SITE NAME: MERIDIAN & REX RD
FA# / SITE ID: 10099189 / COL02090
PROJECT TYPE: LTE 3C / 5G NR
PACE: MRUTH041341 / MRUTH041409
PTN: 3755A0VBB9 / 3755A0VD9Z

MERIDIAN & REX RD

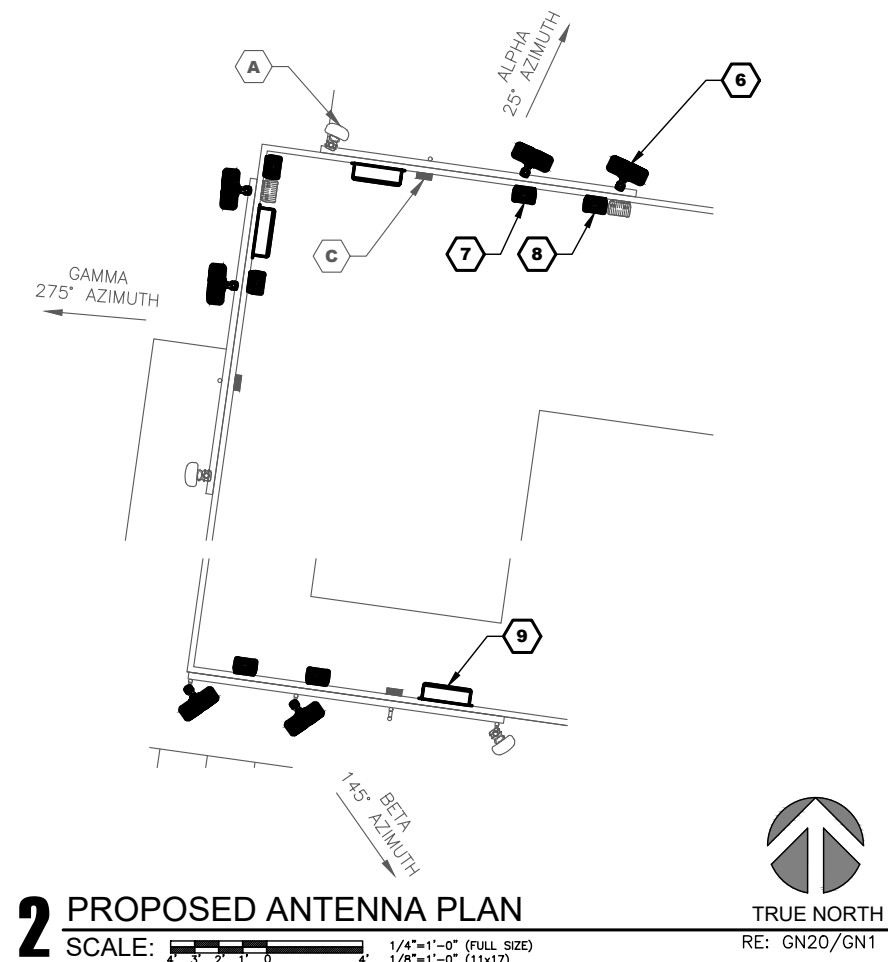
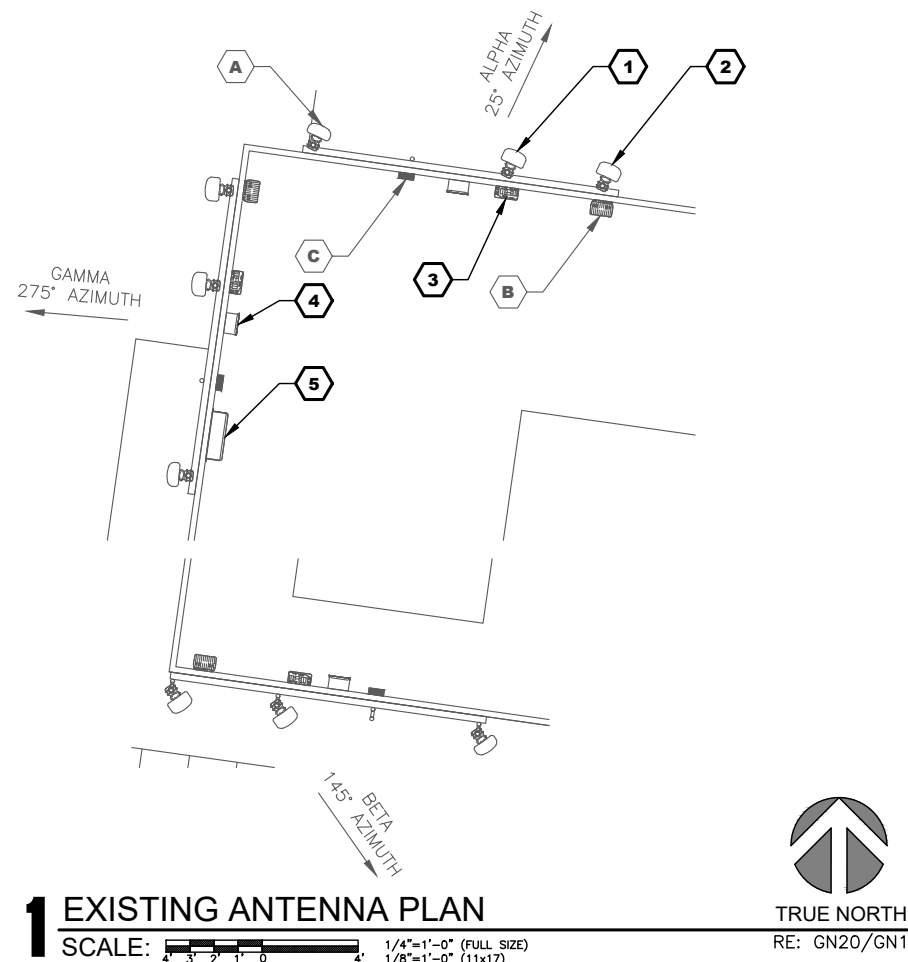
This equipment seems to be wall-mounted rather than rooftop-mounted, as such please include a detail / description of the color to verify that the proposed additions will be painted the same color as the building per requirements.
